Land off Edisford Road, Clitheroe

Addendum- Design and Access Statement

Drawing:
Proposed Site Layout
Drawing No:
ER-P-01

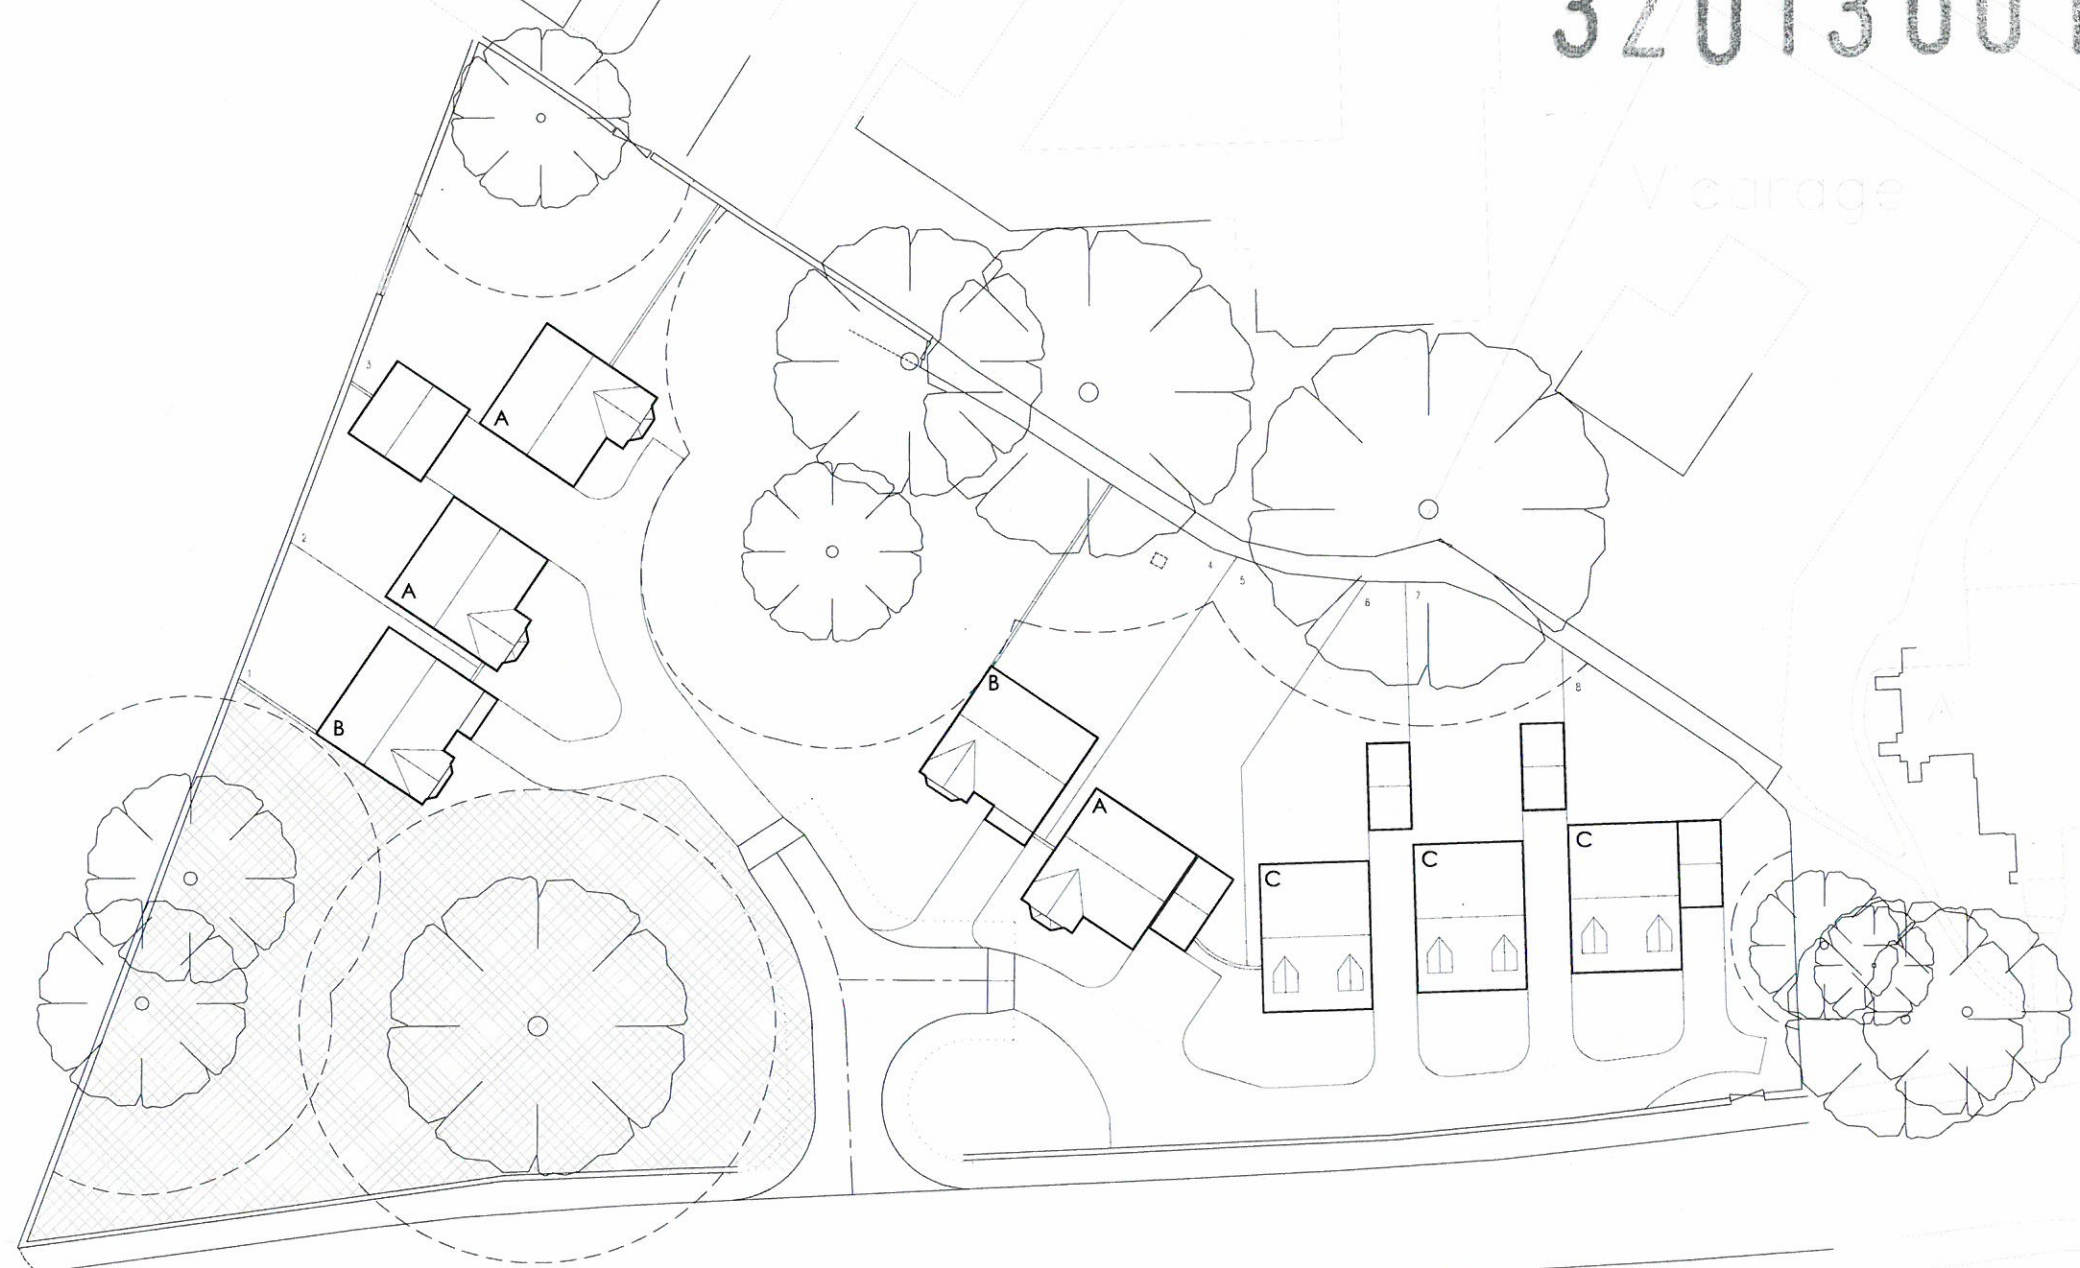
The three indicative plots to the east of the site, closest to the existing Church, have been amended to reduce their overall scale and impact on the adjacent structures. To this end, it is proposed to incorporate dorma-style accommodation at this part of the site.

The indicative house types shown on the revised site layout shows three dorma-bungalows, of approximately 710 square feet footprint.

The approximate eaves height would be c2600mm.
The approximate ridge height would be c6500mm.
